Subject: Cordero Minor Subdivision and Rezone - Review 3 (MS-17-001)

The Planning Division of the Community Services Department has reviewed the Cordero Minor Subdivision and Rezone, Review #3, and continues to acknowledge the 25' public trail easement shown on the Final Plat. At this time, we have no additional comments. Please refer to the original review comments below, as endorsed by the Park Advisory Board on February 8, 2017:

MINOR SUBDIVISION
CORDERO MINOR SUBDIVISION
A PORTION OF THE NORTHEAST QUARTER OF SECTION 1,
TOWNSHIP 14 SOUTH, RANGE 63 WEST OF THE 6TH P.M.,
EL PASO COUNTY, COLORADO

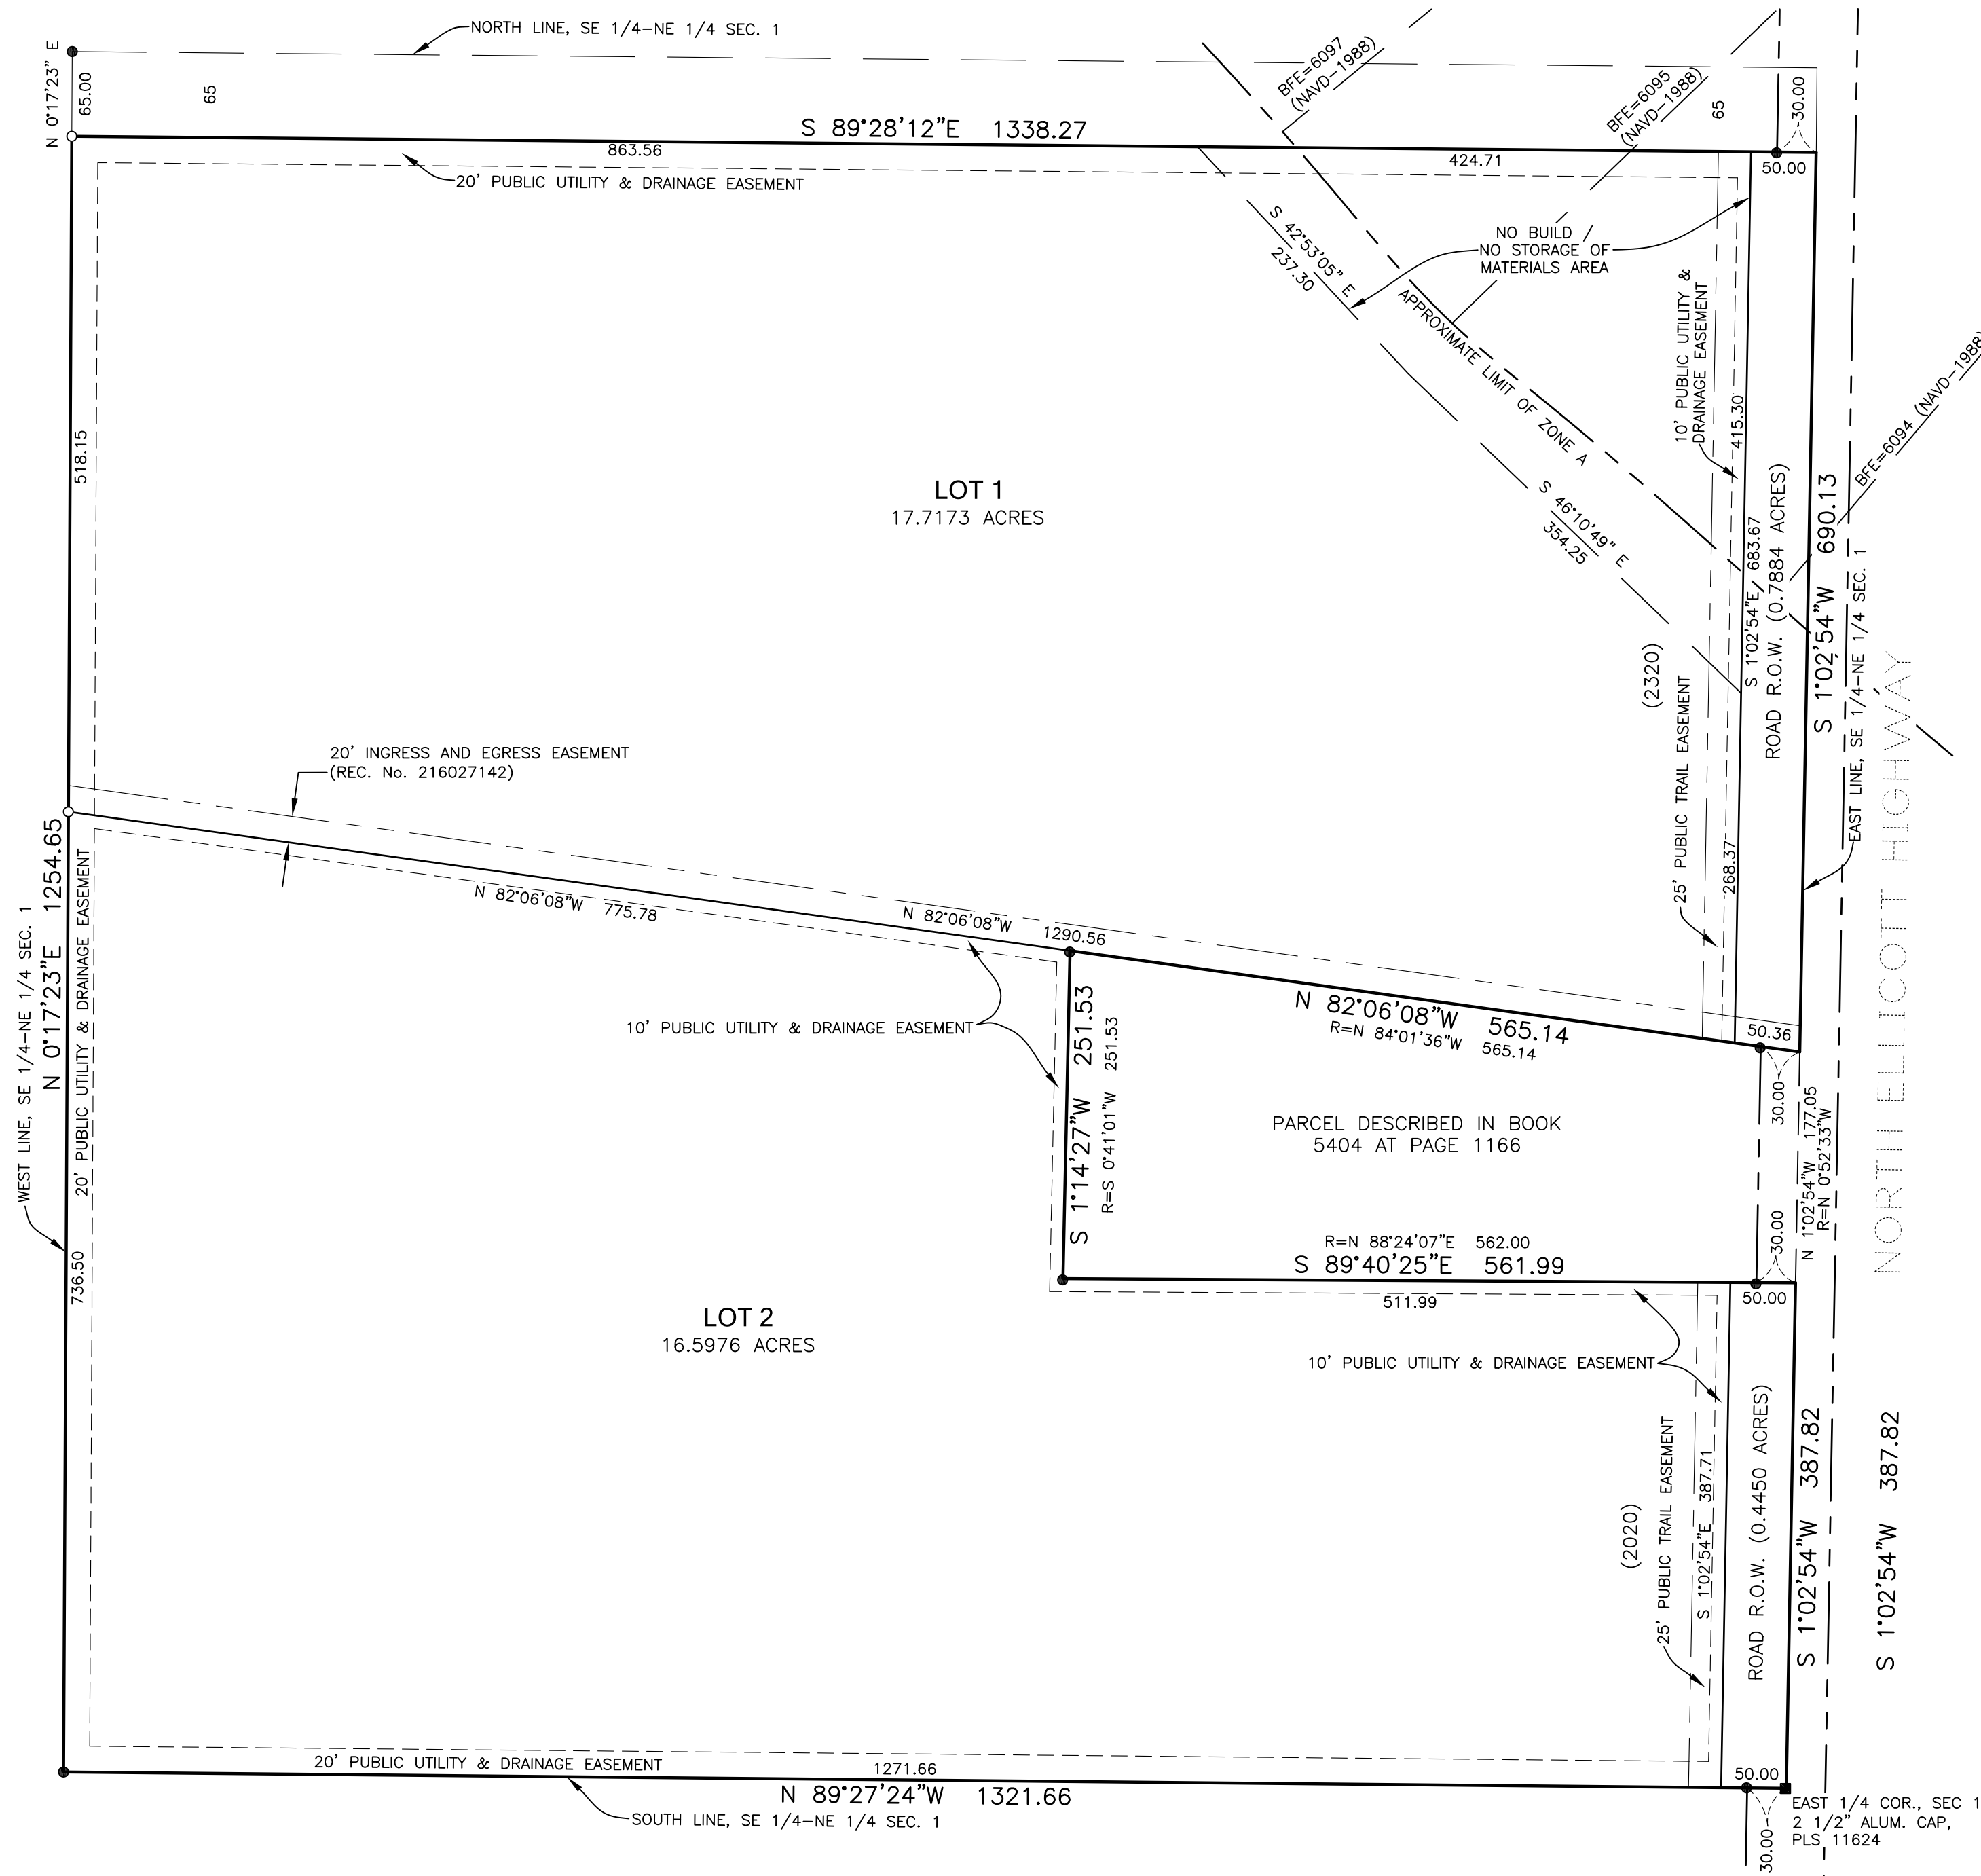
County Parks requests trail easements where development projects impact proposed County trails. As it pertains to this application, the County requests that the landowner provide a 25-foot public trail easement along the west side of North Ellicott Highway that allows for public access, as well as construction and maintenance by El Paso County of a primary regional trail, and this easement shall be shown and dedicated to El Paso County on the Final Plat. Furthermore, staff recommends fees in lieu of land dedication for regional park purposes in the amount of \$814, as shown on the attached Subdivision Review Form.

Recommend to the Planning Commission and Board of County Commissioners that approval of the Cordero Minor Subdivision Final Plat include the following conditions: (1) designate and provide to El Paso County a 25-foot

public trail easement along the west side of North Ellicott Highway that allows for public access, as well as construction and maintenance by El Paso County of a primary regional trail, and this easement shall be shown on the Final Plat, and the aforementioned easement be dedicated to El Paso County on the Final Plat; (2) and require fees in lieu of land dedication for regional park purposes in the amount of \$814.”
